**Consultation Response from Mike Hibbert,
KC Waste Strategy(Refuse & Recycling)**

2023/93296 75a, North Road, Kirkburton, Huddersfield, HD8 0QE

Conversion and alterations of existing office into living accommodation (within a Conservation Area)

Responding Ref: WPS 23-59

cBent			
Mr. L. BENTLEY			
project	PROPOSED CONVERSION OF EXISTING OFFICE INTO LIVING ACCOMMODATION		
address	75A NORTH ROAD KIRKBURTON HUDDERSFIELD HD8 0QE		
drawing title	SITE PLAN		
scale	prefix	drawing No	rev
1:200 @A4	2023.16	(LB) SP 01

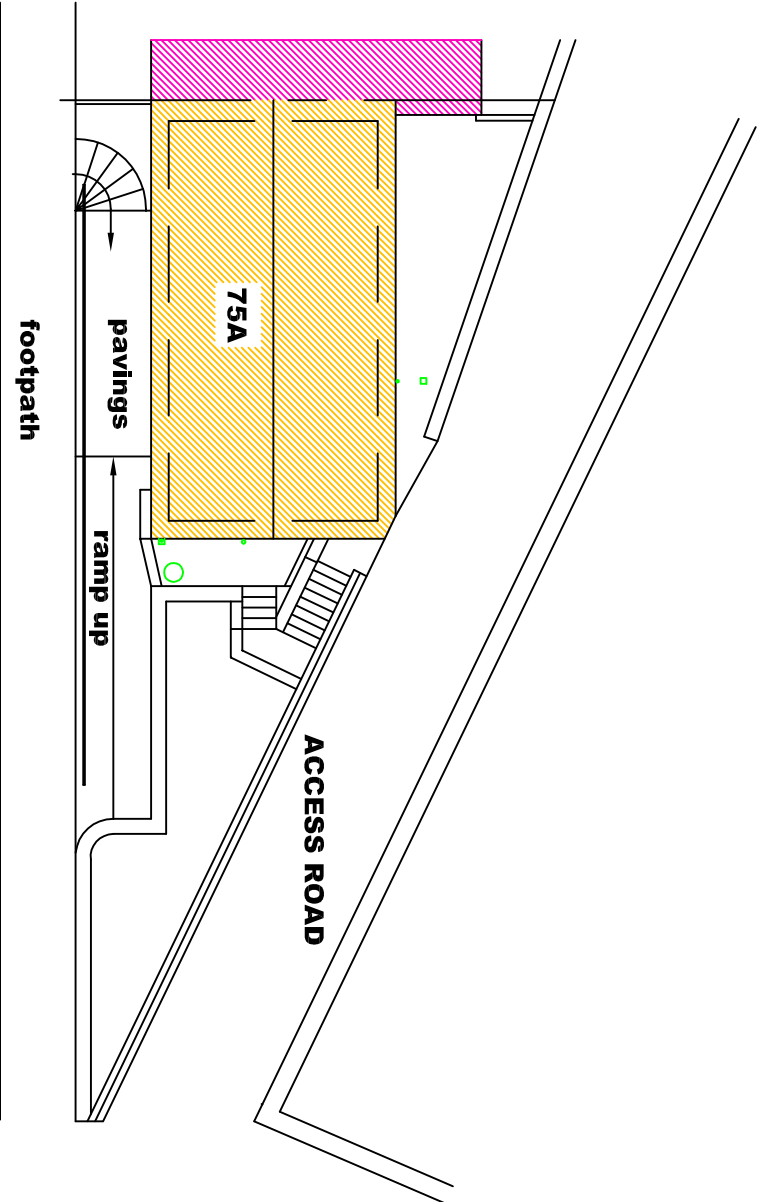
- Space will be required to accommodate storage of 3 x 180 ltrs or 240ltrs wheelie bins for the property (1xResidual, 1xRecycling and space to accommodate future changes / new collection arrangements of additional waste streams).
- Guidance indicates the storage footprint for a 240ltrs wheeliebin is 940mm x 780mm with enough room to allow removal of the bin from the storage location. The floor plan for the storage area must be large enough to accommodate 3 x240ltrs bins for the dwelling. The bin storage area should be constructed to the specifications detailed in the Kirklees Waste Management Design Guide 2020.

- Storage on the footway in front of the property on North Road would be acceptable.
- On collection day the residents would need to transfer bins to a presentation point close to the adopted highway and not left on the footway. The location of bin store and presentation point will need to be shown on the site layout plan. It is important to ensure that bins do not cause obstruction to pedestrians or other highways users when presented for collection, particularly where space requires these to be left in clusters.
